DRB Application No.: 03-01123 (P&F)	Project # 1002799
Project Name: Netherwood Park Addition	EPC Application No.:
Agent: Surveys Southwest	Phone No.: 998-0303

D.R.B. CASE NO.: 1002799 DATE: 7/16/03 ITEM NO.: 10

REQUEST FOR: Prelim/Final Plat

PLAT OF
TRACT B-1-E-1
NETHERWOOD PARK ADDITION
SECTION 11, T. 10 N., R. 3 E., N.M.P.M.
CITY OF ALBUQUERQUE
JULY 2003
SHEET 2 OF 2

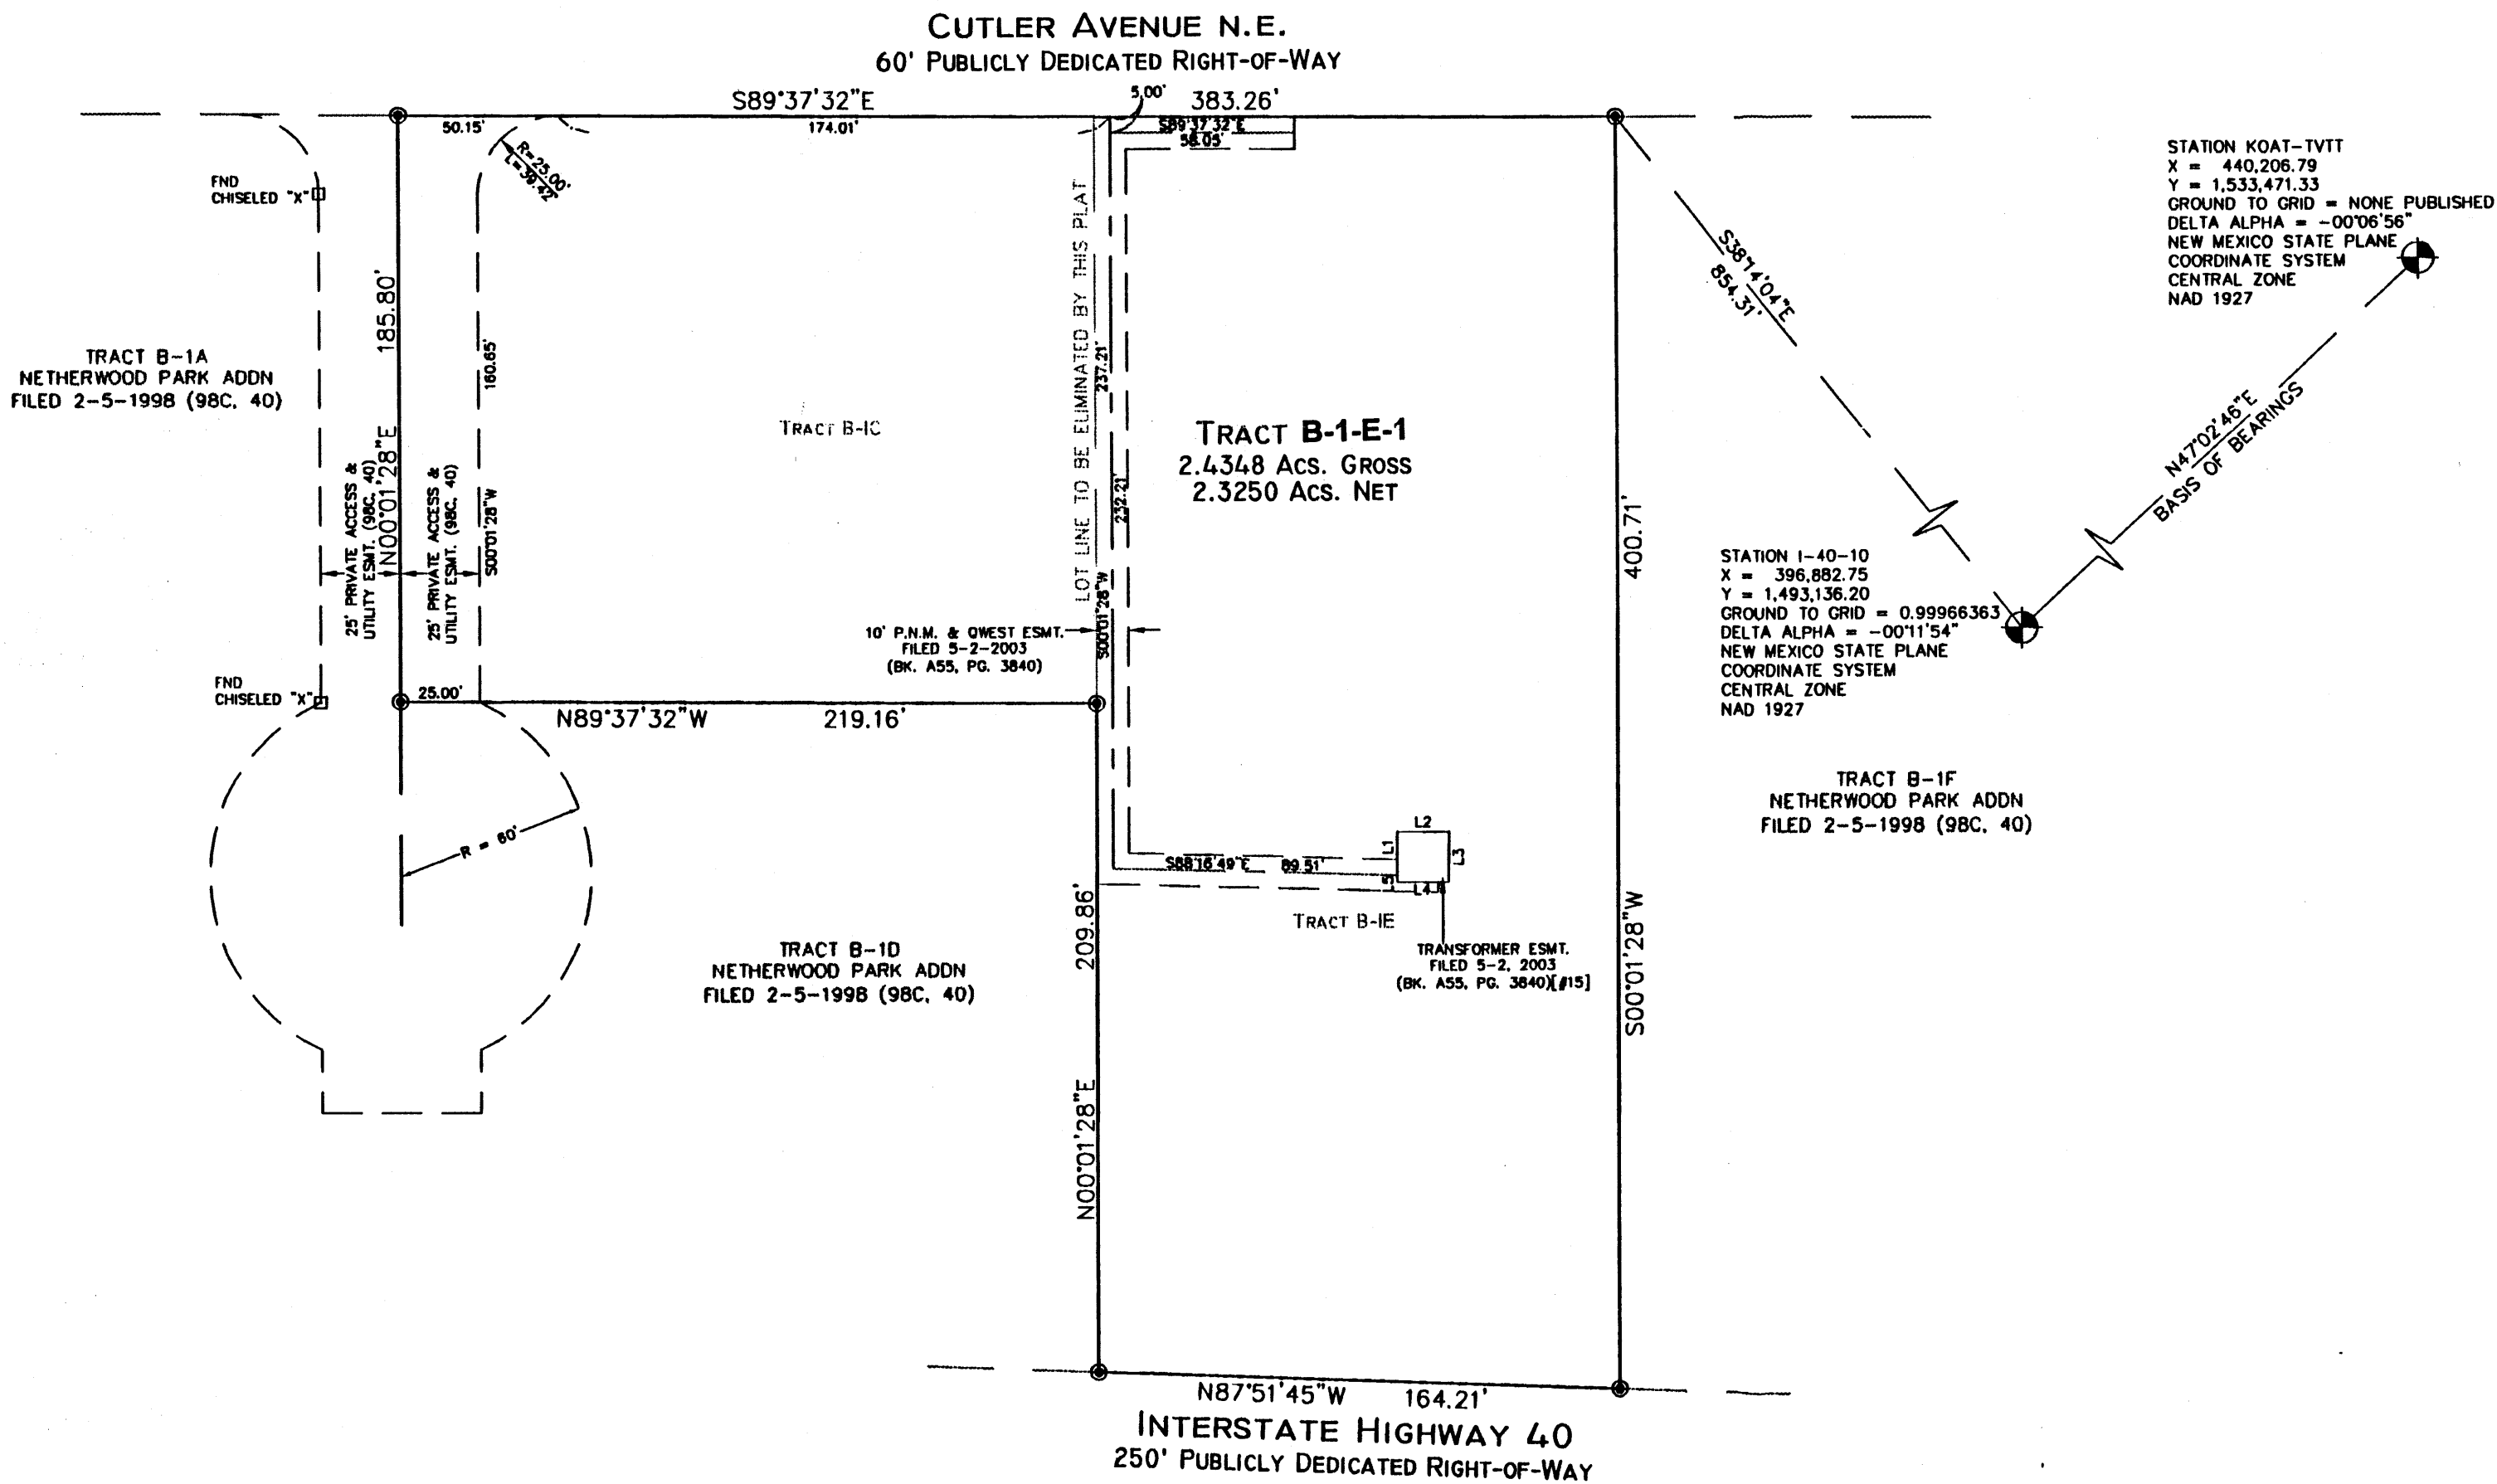
The 25' easement along the west property
line should be revised to:

" 25' PRIVATE ACCESS AND PUBLIC UTILITY AND
CITY WATER AND SANITARY SEWER EASEMENT "
